Addendum No. 1

RE: Contract ID C203011

WBS # 17BP.12.P.3

Bridge #20 On NC-10, 66 On Old NC-127, 26 & 99 On NC-150, 71 On US-21,
109 & 162 On I-40W, 201 On I-77S and 161, 1 50 & 154 On Various SR

REVISIONS						SHEET NO.
NO.	BY:	DATE:	NO.	BY:	DATE:	S-2
1			3			TOTAL SHEETS
2			4			65

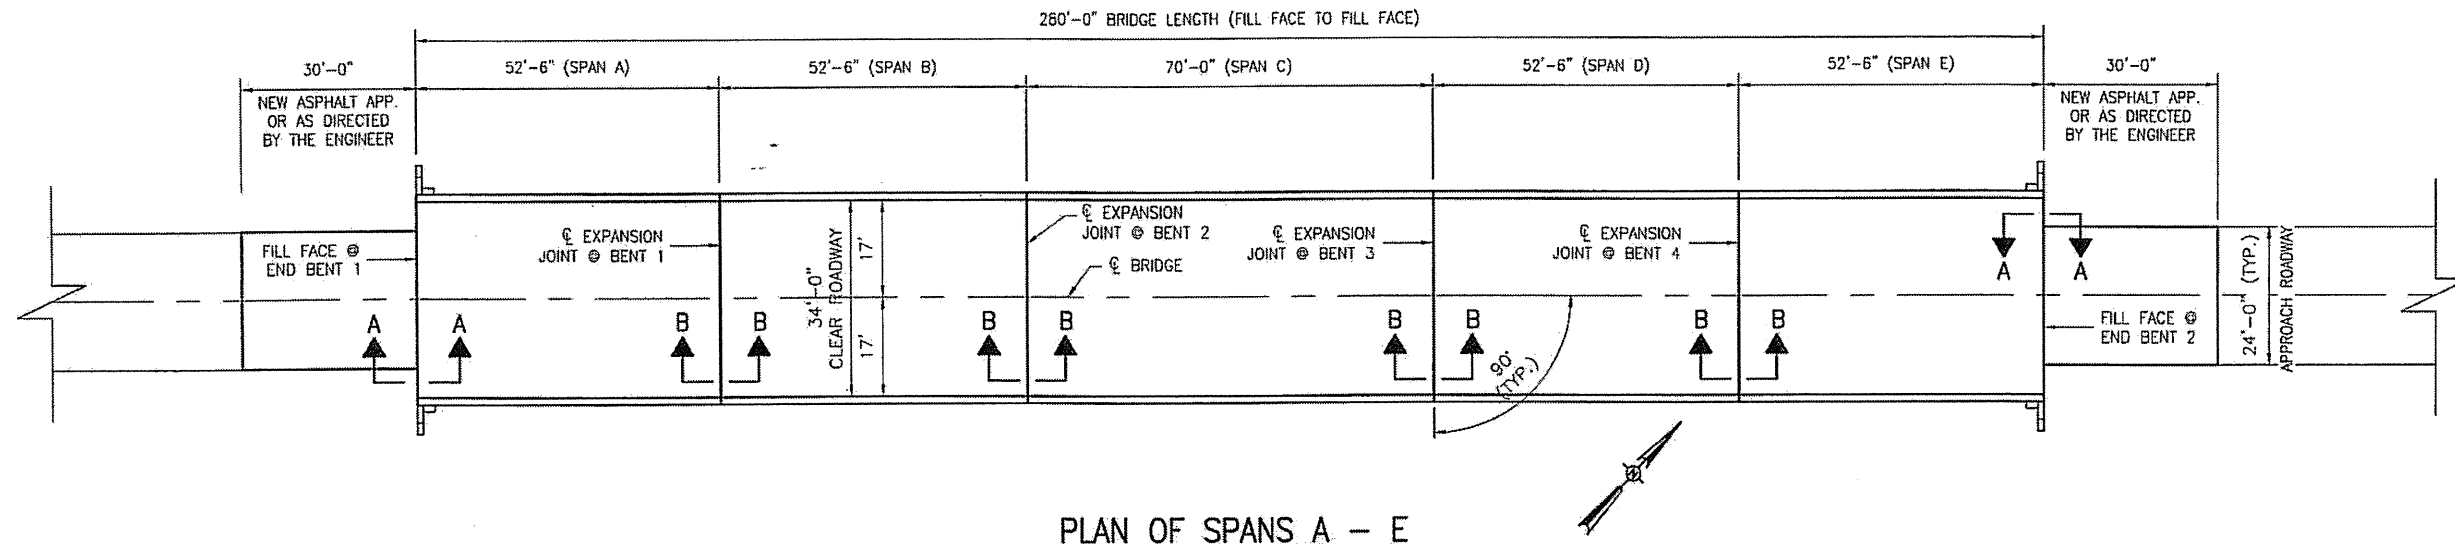
Sheet No. S-2 has been revised to reflect the below noted pay item revision. Please void Sheet No. S-2 in your plans and staple the revised Sheet No. S-2 thereto.

<u>Item</u>	<u>Description</u>	<u>Old Quantity</u>	<u>New Quantity</u>
13-4455000000-N-1150	Flagger	1,344 DAY	DELETED
13-4450000000-N-1150	Flagger	NEW ITEM	1,344 HOUR
